Our Ref: P25357-FT-EN-XX-RP-PL-0002

09th February 2026

**Re: Response to Galway County Council Planning Authority Report**

Figure 5-7: Proposed Passing Bay Locations

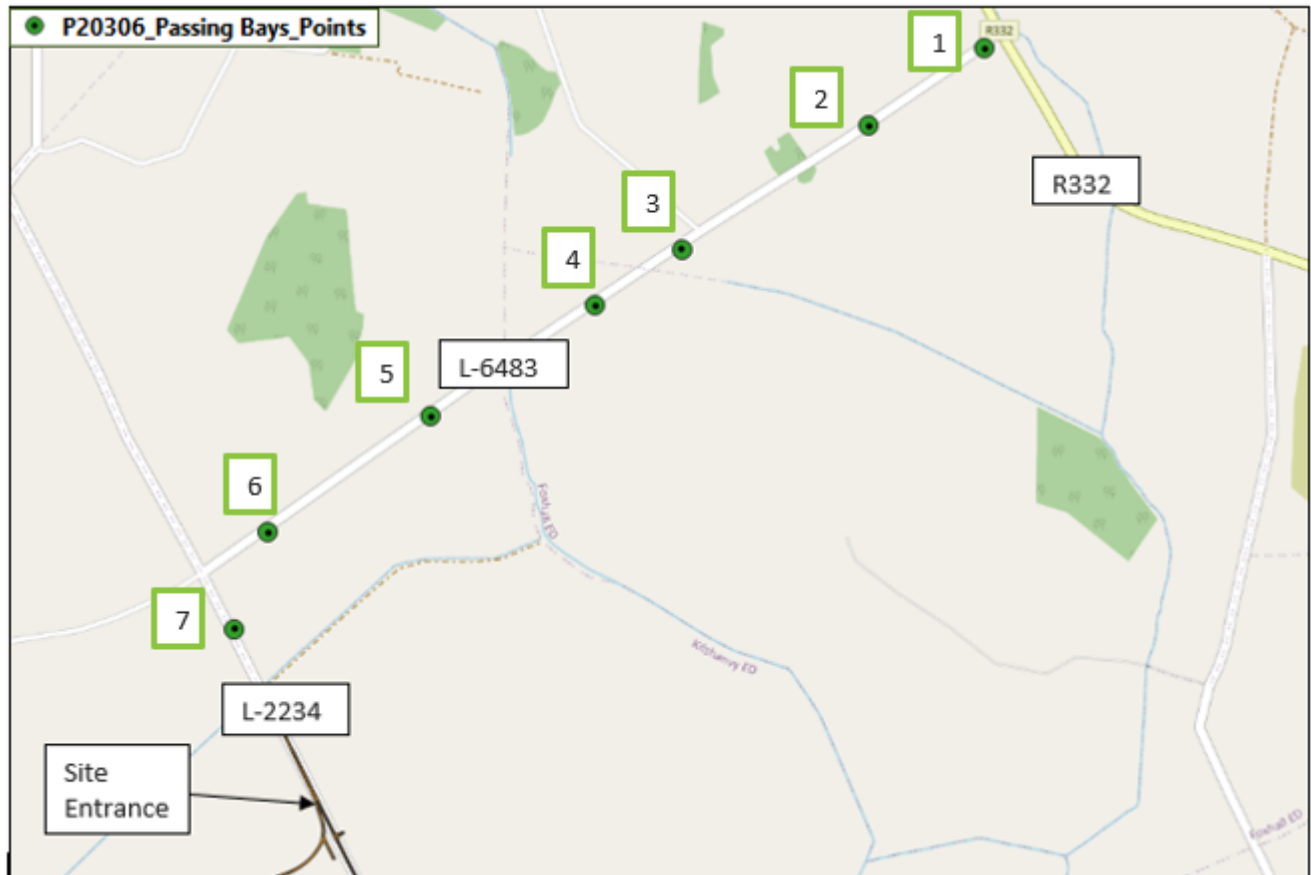
As a point of clarity to the Roads Department comment that “no provision of passing bays” has been provided, section 5.3.2.1 of Appendix 14.2 (Traffic Management Plan) of the EIAR provides a detailed analysis of the local road capacity and includes proposals for road widening and for the construction of passing bays (for two large tipper trucks) at 7 no. locations along the L-6483 and L-2234. The grid route and substation access has equally been assessed for passing opportunities and road capacity as per Section 5.4 of the Traffic Management Plan. As such, the necessary infrastructure to allow for contraflow manoeuvres in accordance with TII Publications DN-GEO-03031 Rural Road Link Design is designed for in the project.
